Our Ref: ID 3850
Your Ref: SSD-65595459

2 June 2026

State Significant Development Application for Hunter Indoor Sports Centre (HISC)

C-2

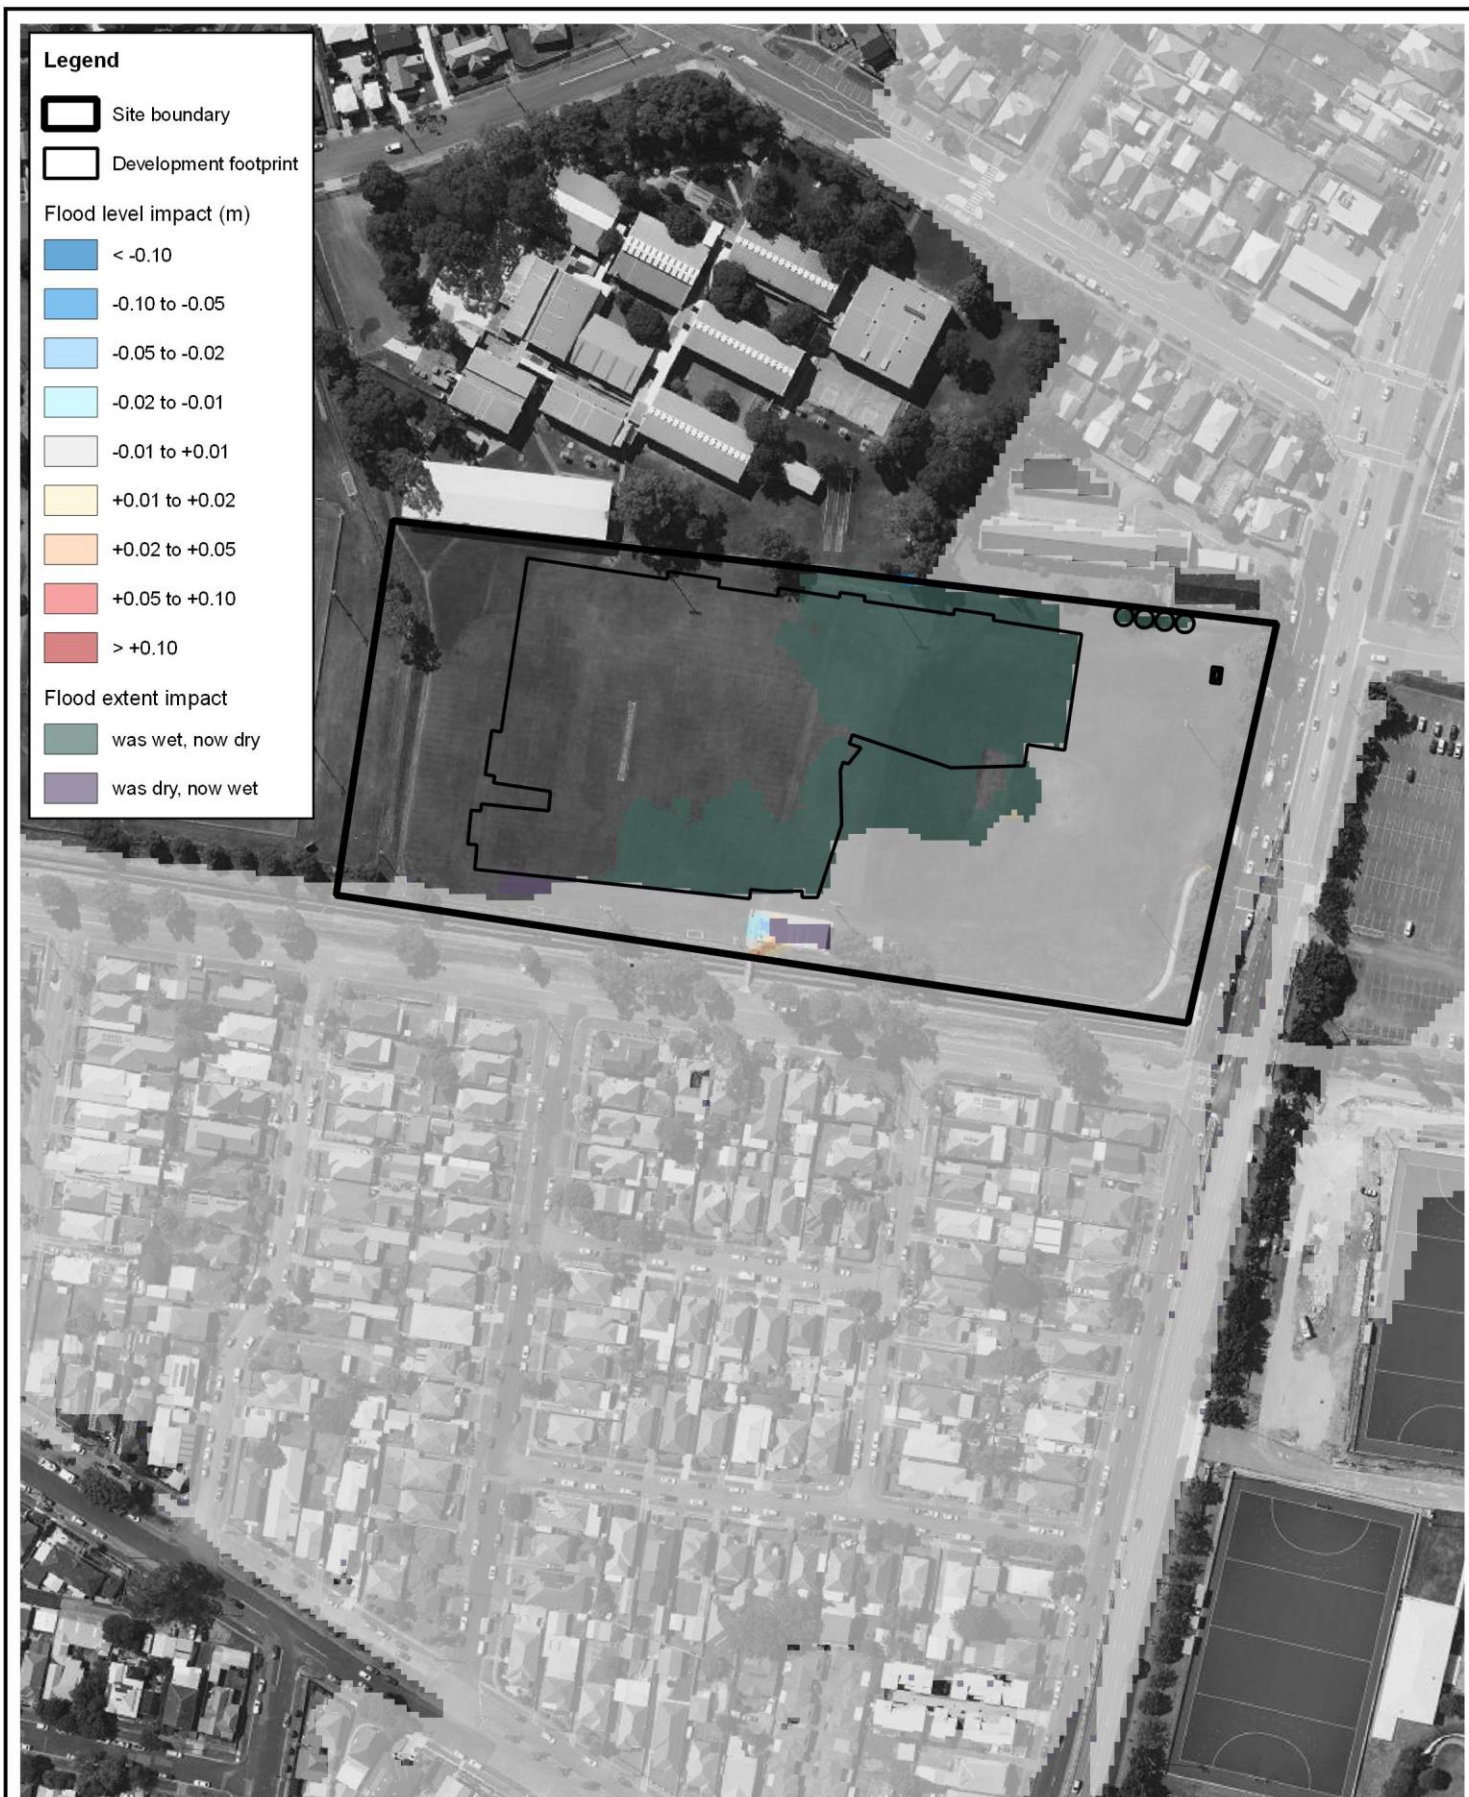
In a 5% Annual Exceedance Probability (AEP) event post-development conditions, flooding within the site is generally contained within the swale, with some low hazard (H1) flood affectation around the site access point onto Turton Road.²³ The modelling suggests that in post-development scenario, flooding conditions in the eastern part of the site, including around the site entry to slightly improve, showing a reduction in flood levels in events more frequent than the 2% AEP.²⁴ However, site vehicular access is cut in events rarer than the 2% AEP event, with access/egress onto Turton Road cut by H3 hazard level flooding in a 1% AEP event.²⁵ Flooding progressively encroaches onto the site, with complete inundation occurring in the Probable Maximum Flood (PMF) event, with **high hazard flooding (H5 flood hazard level)** along the site's southern boundary and the entire eastern part, including access onto and Turton Road itself experiencing high hazard flooding.²⁶

²⁴ Torrent Consulting. 2026. Hunter Indoor Sports Centre – Flood Impact and Risk Assessment (Revision 09), Figure C-1 & C-2
